WRITTEN SUBMISSION OF ORAL CASE (ISH2)

M54-M6 LINK ROAD
M6 DIESEL SITE AT SAREDON

Project	M6 Diesel site at Saredon & M54-M6 link road		
Document Number	SAR-BWB-GEN-XX-RP-TR-0006	BWB Ref	NTH2442
Author	Simon Hilditch	Status	S2
Checked	Alan Darby	Revision	P1
Approved	Peter Selfe (M6 Diesel)	Date	08.01.2021

Drawing Number	Highways England PIN	1 Originator	1 Volume	Rev
HE514465	-ACM	-HGN-		P10
Z3 SW_PR_Z		-DR-CH-1006

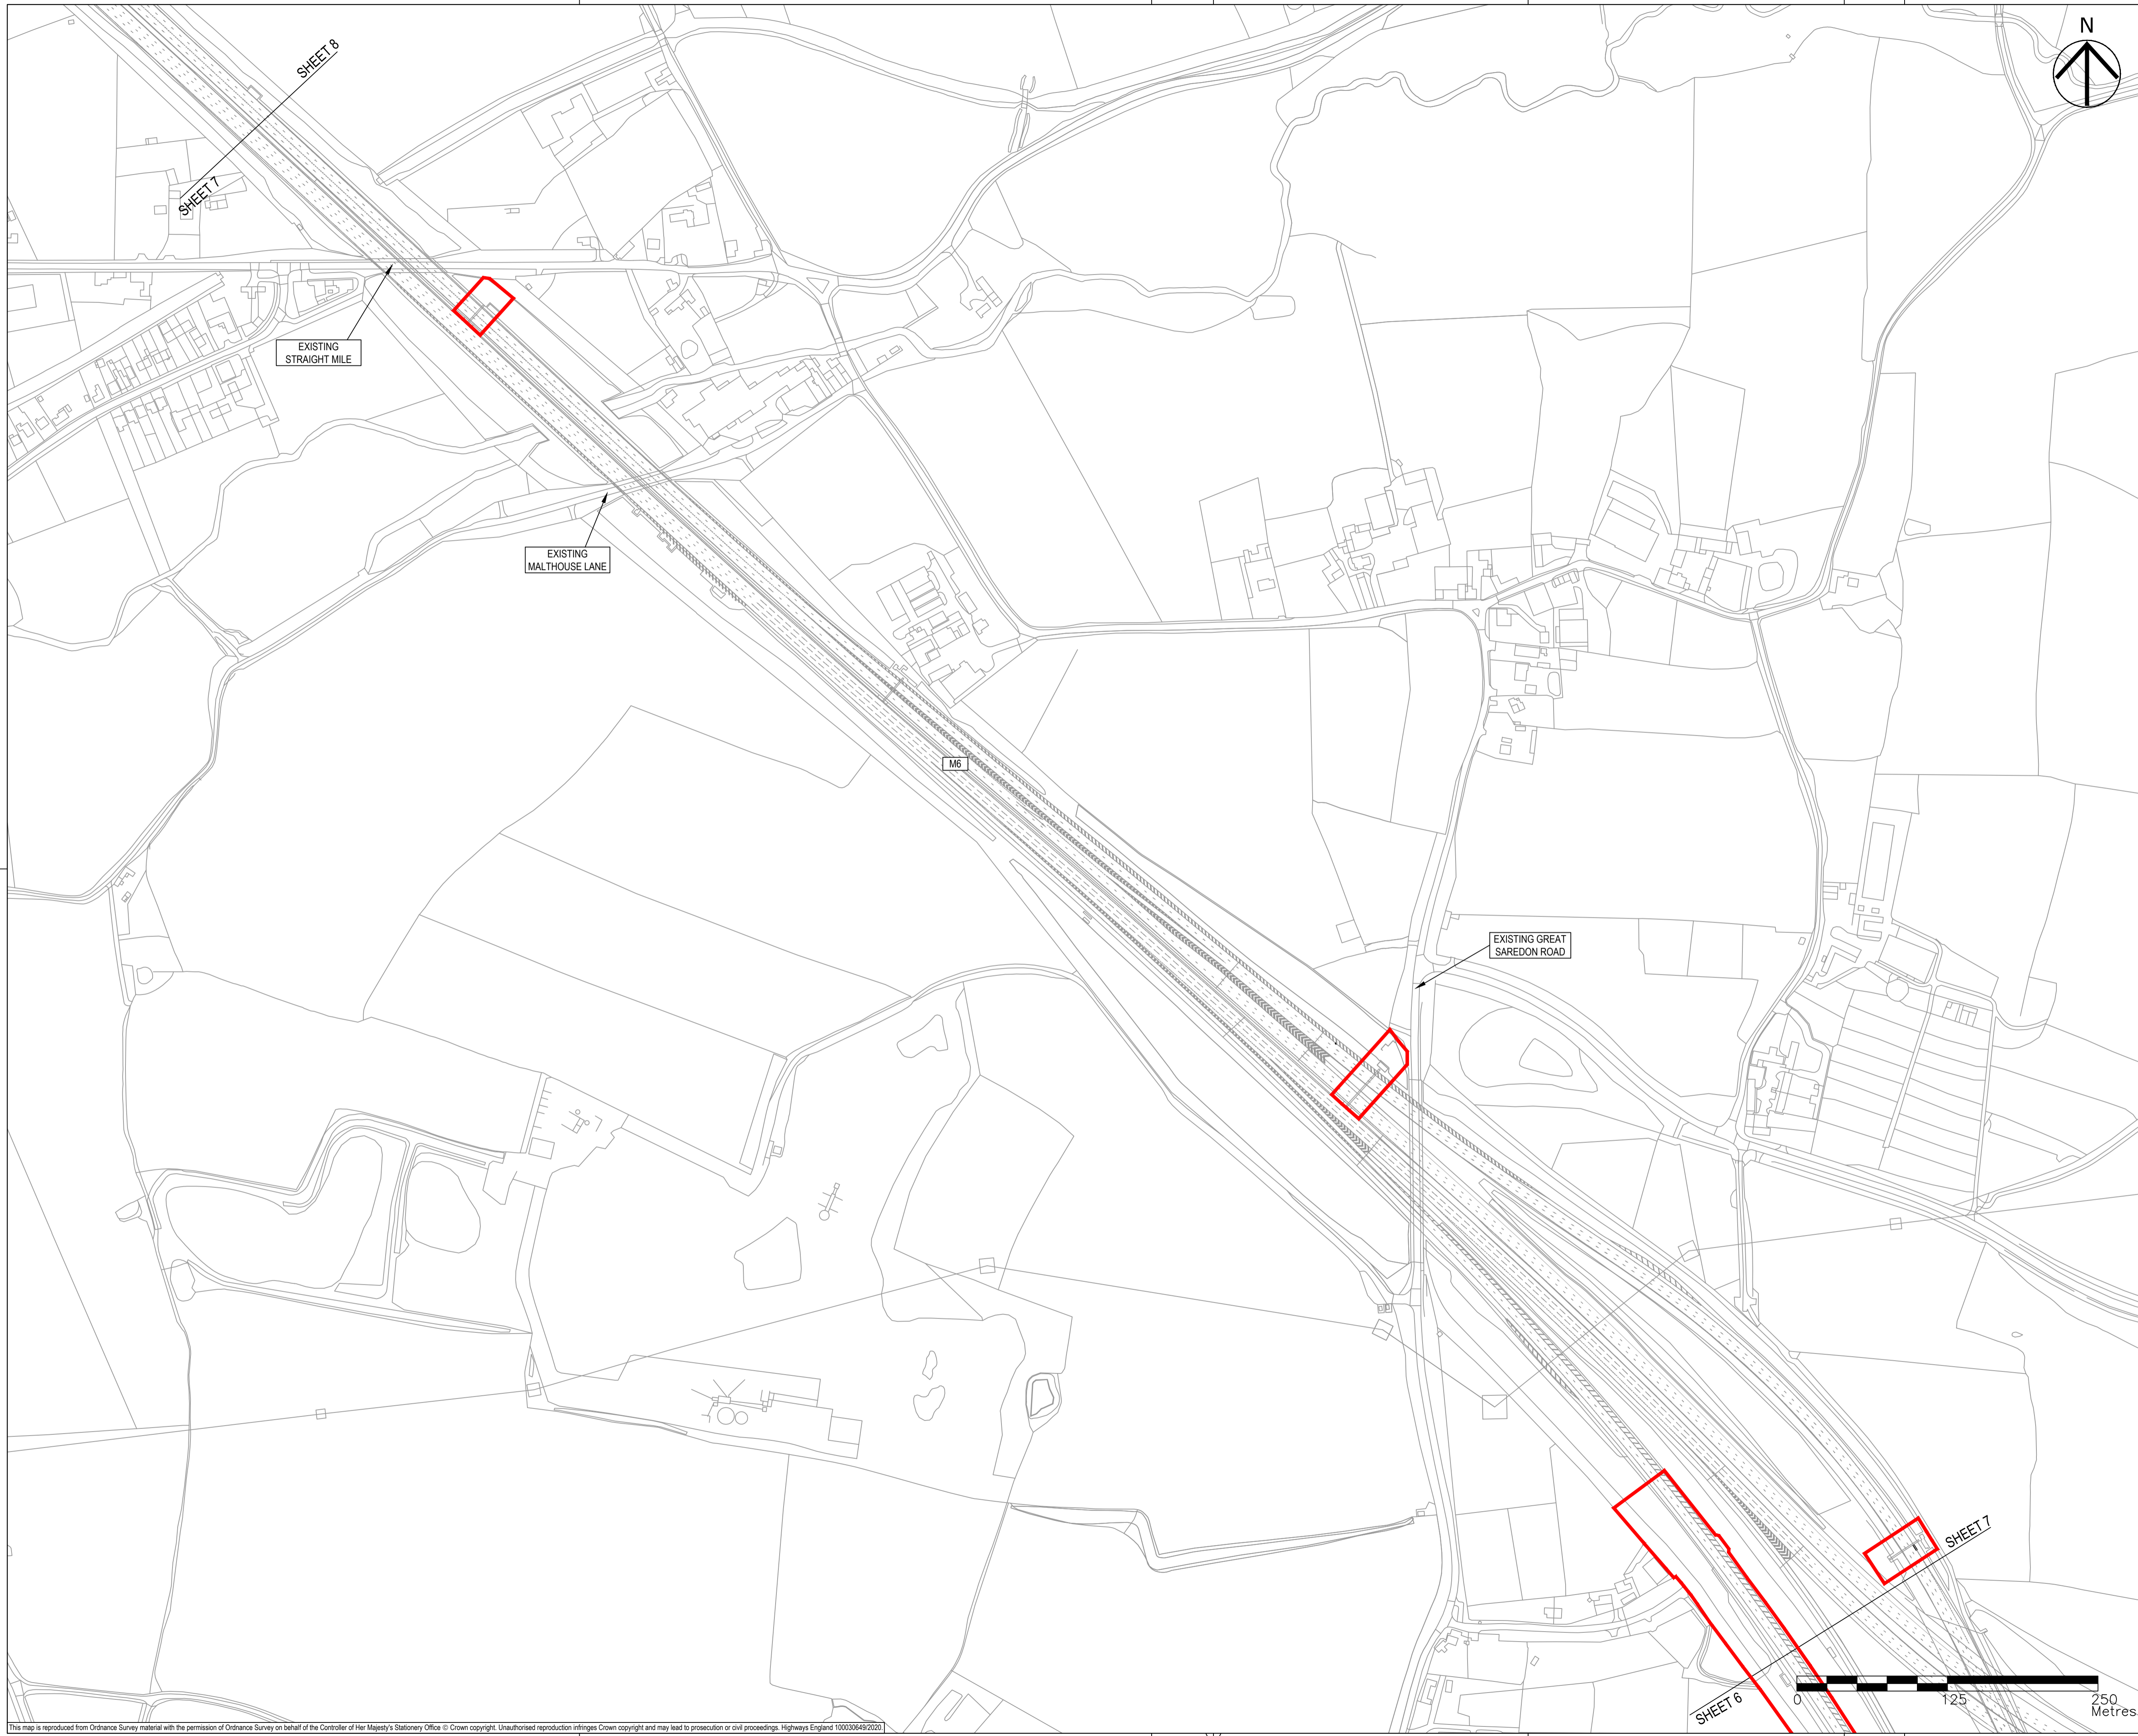
- 2.2 As we presented at ISH2, the proposed signalised gyratory has multiple parallel lanes, up to six in places. The risk of drivers being in the wrong lane increases with the complexity of the layout and hence the importance of signage increases. We therefore consider it essential for all HGVs, including the large number seeking the M6 Diesel site, to be in the correct lane whilst using the gyratory.

- 2.3 To emphasise how difficult it could be for HGV drivers seeking the M6 Diesel site navigating the signalised gyratory, we have shown on **Figure 1** below the vehicle path that an HGV from the M6 Southbound seeking the existing A460 exit has to take. The road layout used in this figure is extracted from the Applicant's general arrangement plan sheet 6 [AS-067].

- 2.4 Of particular concern is the requirement for HGVs to be in either lane 3 or 4 when heading across the south bridge (it is unclear from the Applicant's general arrangement plan whether vehicles proceeding to the existing A460 are to be in lane 3 or 4) and then immediately cut across four (or five) lanes to be in lane 1 before the traffic signal stop line at the entry for the new link road. We have shown on **Figures 2** and **3** below the potential safety implications of HGVs being in the incorrect on the southern bridge. Again the road layout is extracted from the Applicant's general arrangement plan sheet 6.

- 2.5 It is our view that the issues highlighted provide clear justification for signage to be provided to the M6 Diesel site to minimise the risk of significant numbers of large and heavy vehicles being in the incorrect lane when using the signalised gyratory. In particular the signage needs to clearly define how HGVs are expected to use the gyratory across the southern bridge and then take the exit for the existing A460.
